From: Anita Gardner
Sent: 23 February 2018 15:53
To: Planning.Responses
Subject: FW: CM/35/17/PL

Dear Mrs Gardner,
the bricks are Terca Cassandra Multi facing brick - 24847 as per CM/27/17/DOC.
they are very similar to the Thakham dark brown bricks.

ELEVATIONS

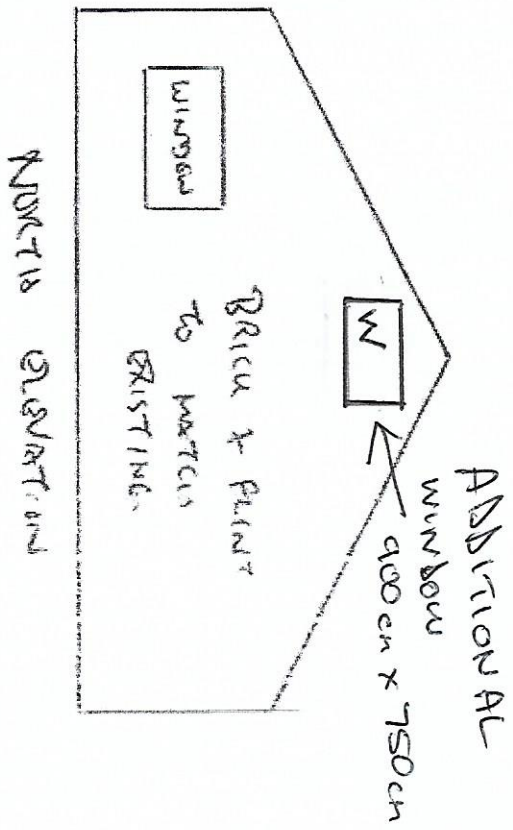
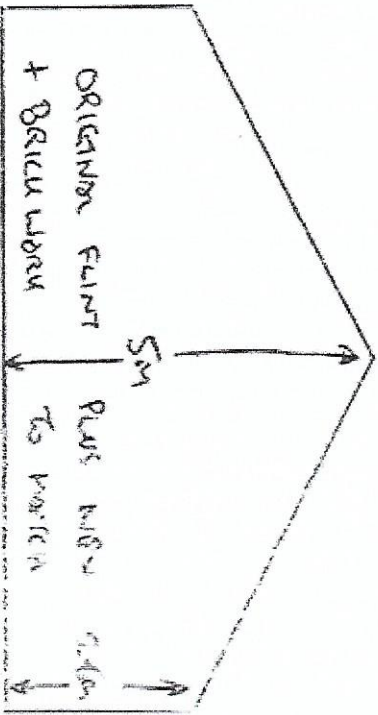
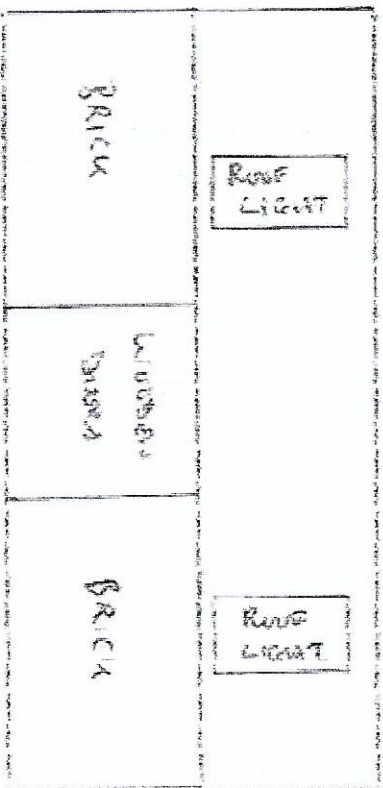
Thank you for the confirmation. Are the elevation materials Thakeham dark brown terracotta bricks with local flints as per CM/28/16/DOC?
